Development Control  
Ribble Valley Borough Council

**Re:** Planning Application 19/0356

**Address:** Startifants Farm Goose Lane Chipping PR3 2QB

**Description:** Demolition of existing farm house and erection of replacement dwelling. Change of use of barn to one live/work unit including conversion of an existing building to garage. Demolition of existing farm buildings. (Resubmission of Application 3/2018/1081).

Client Details:
Mr & Mrs. R. Robinson
Project Date:
Proposed site plan.

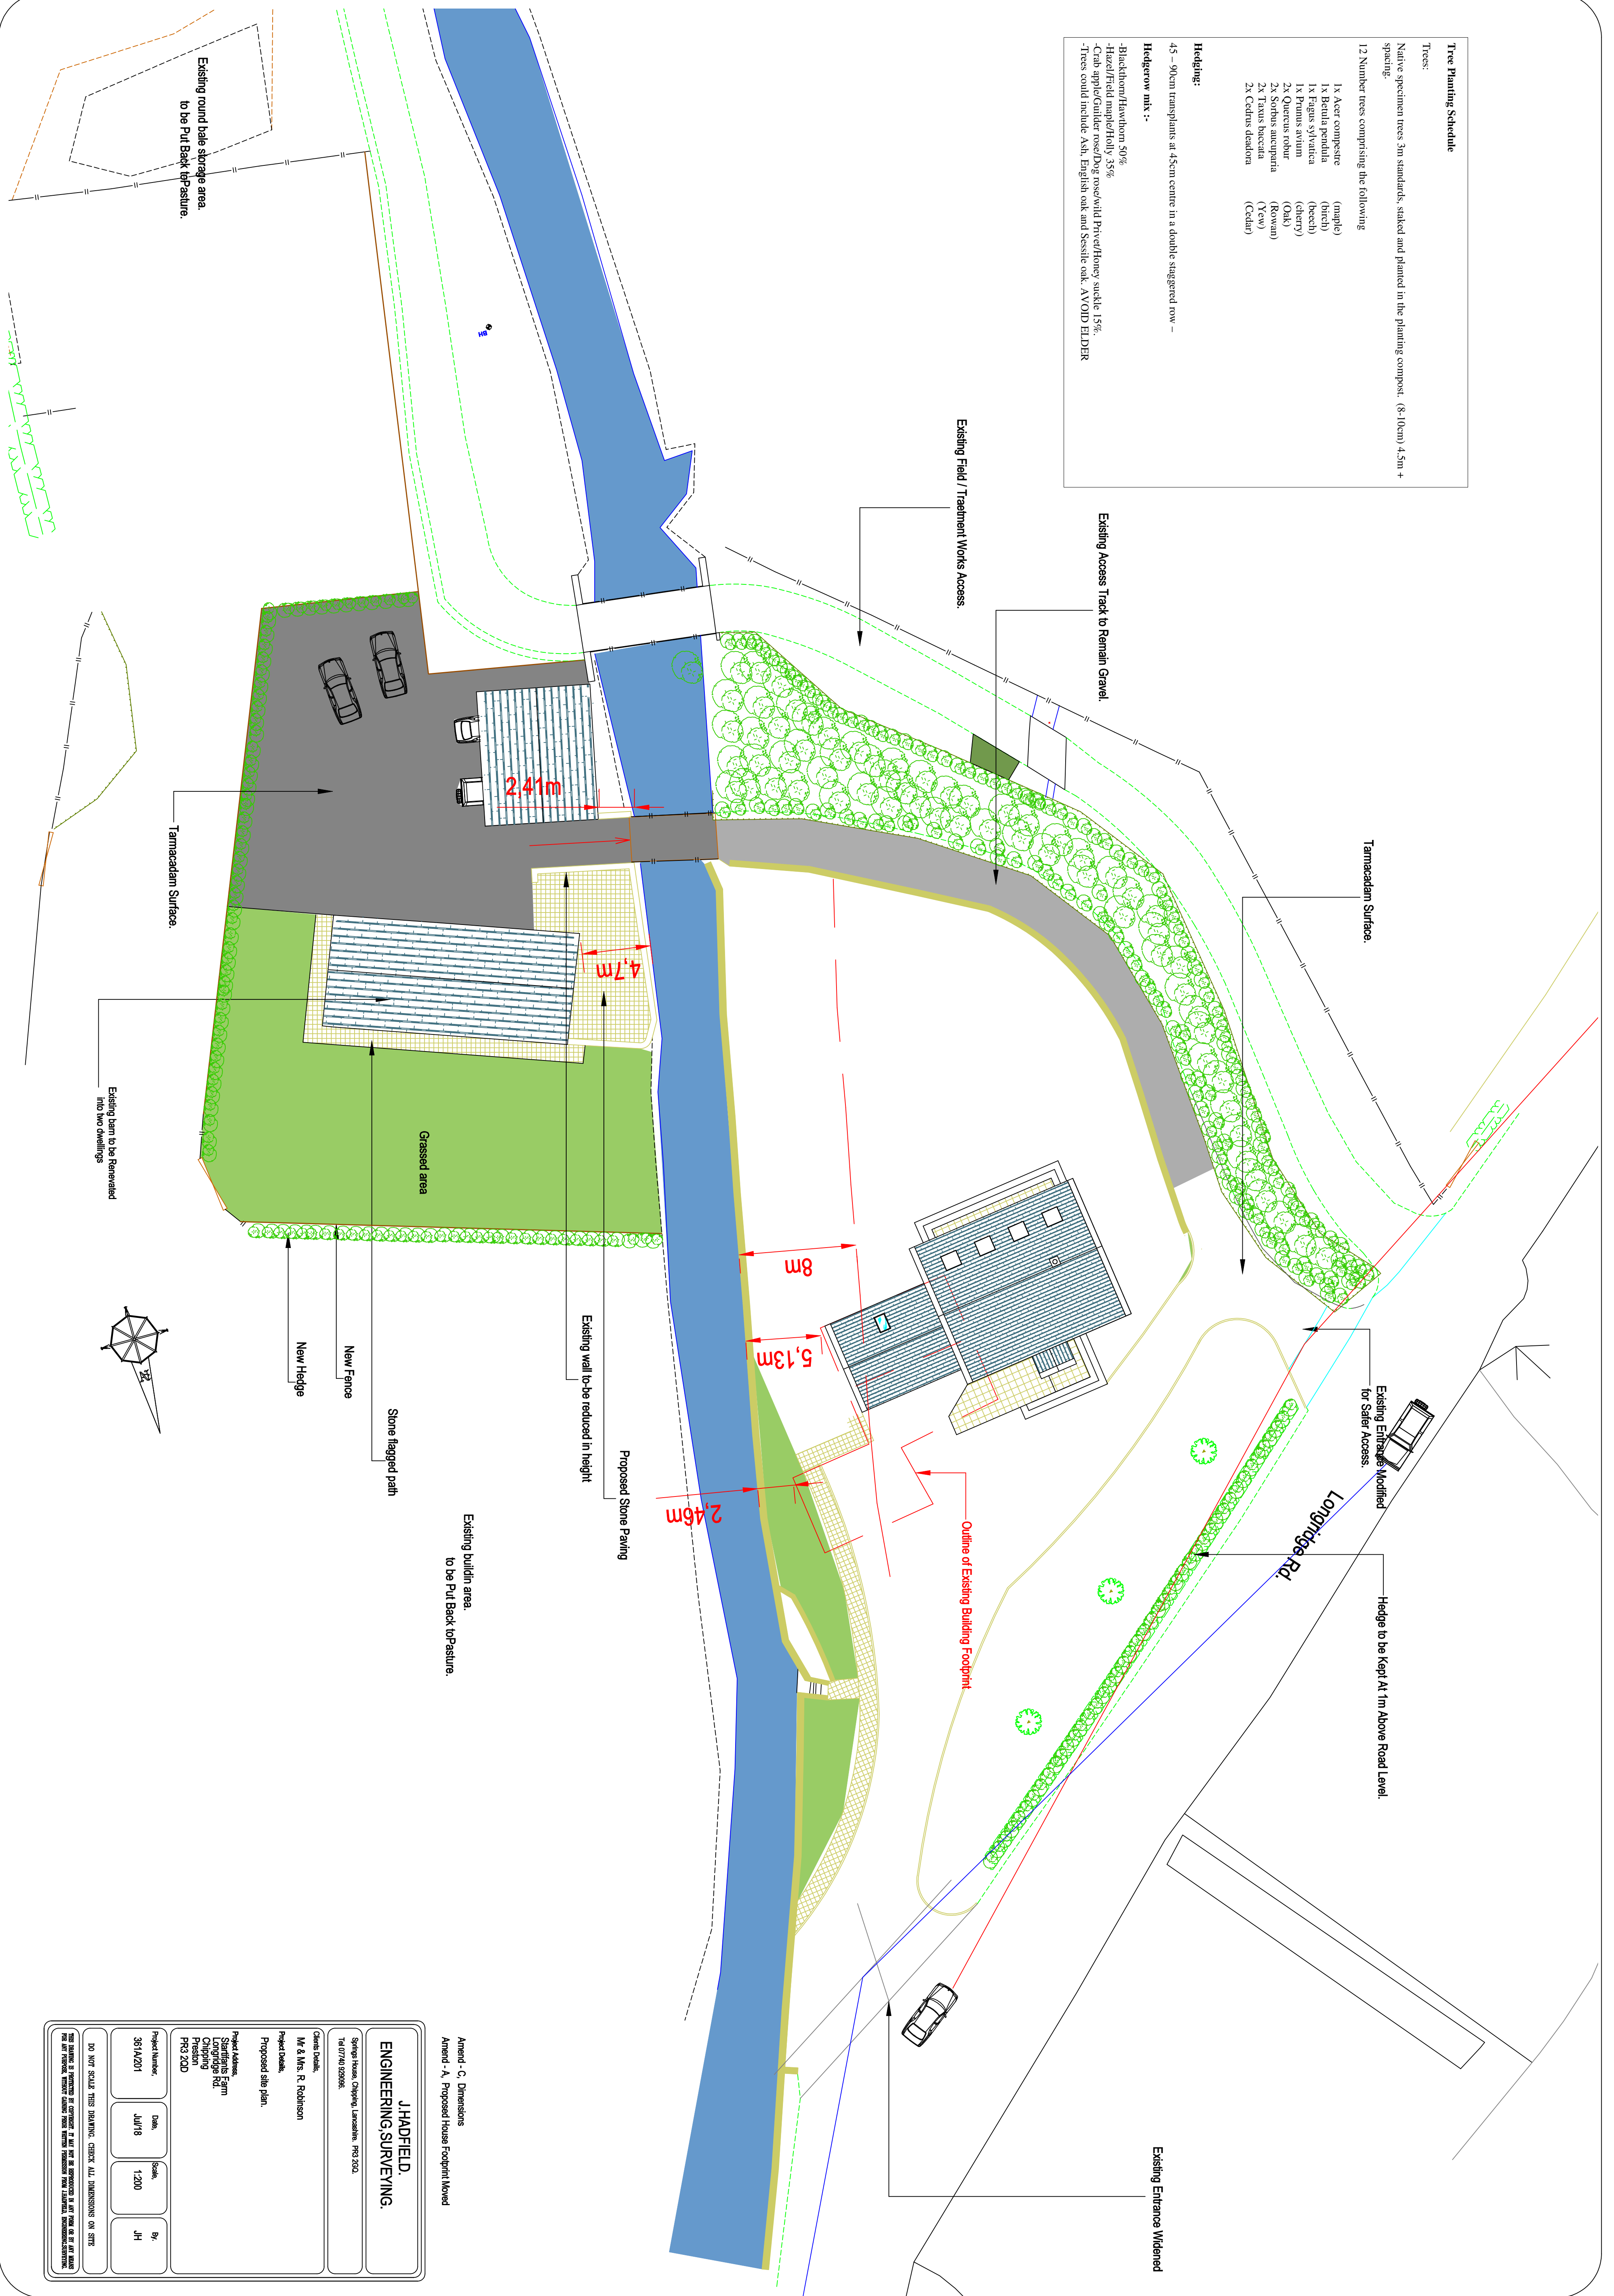
Previous responses to earlier applications made references to the separation of residential and farm traffic, this has been addressed with this application.

1. Before the development hereby permitted becomes operative, all of the curtilage between the farm access track and the access to the north of the plot shall be kept free from obstructions such as walls, fences, trees, hedges, shrubs, ground growth or other structures along the frontage that shall not be in excess of 1.0 metre in height above the height at the centre line of the adjacent carriageway shall be maintained thereafter. **Reasons:** To ensure adequate visibility at the street junction or site access in the interest of highway safety.
